Our ref: CE/2009/103015/02-L01
Your ref: 3/2009/0791

**PROPOSED MIXED USE DEVELOPMENT COMPRISING VOCATIONAL
LEARNING CENTRE, CHILDREN'S NURSERY, COMMERCIAL ELEMENT, 10
LIVE/WORK UNITS AND 70 RESIDENTIAL UNITS - ADDITIONAL INFORMATION
RECEIVED
LAND AT BARROW BROOK, BARROW, CLITHEROE**

I refer to the above and the following information which was received from Harrison Pitt Architects on 2 November 2009:

2.1 Proposed Site Plan.

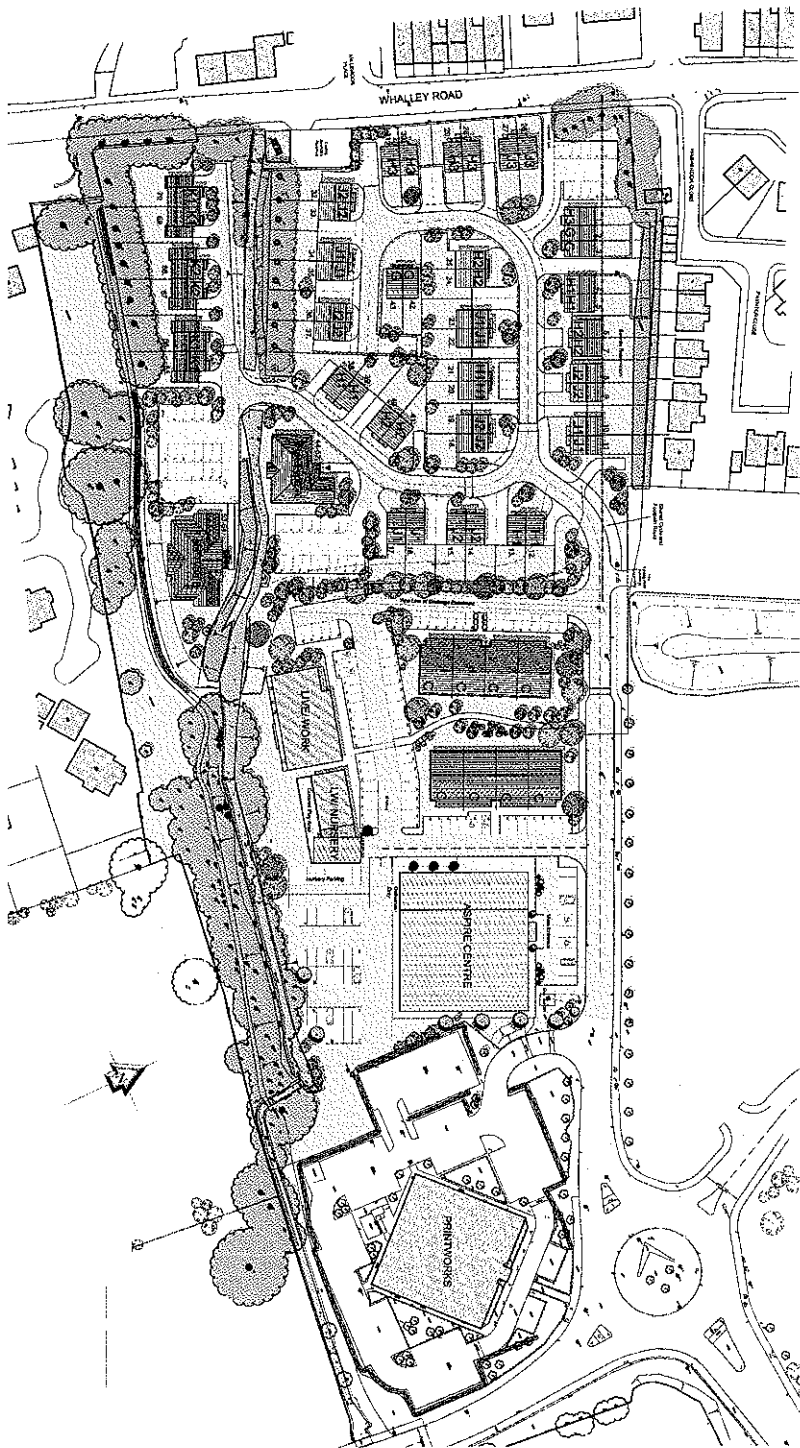
The amended site plan shows the inclusion of a 4 metre buffer zone between the watercourse and any buildings or car parking or private garden space. We are therefore satisfied that the proposed development will not have an adverse impact on the river corridor and we **withdraw our objection**.

The vegetation within this 4 metre buffer zone should consist of the existing habitats on the site and not contain introduced non-native landscaping. To ensure effective management of the buffer zone we recommend that any subsequent planning approval is conditioned as follows:-

CONDITION No development shall take place until a scheme for the boundary treatment adjacent to the watercourse has been approved by the Local Planning Authority and completed in accordance with the approved plans.
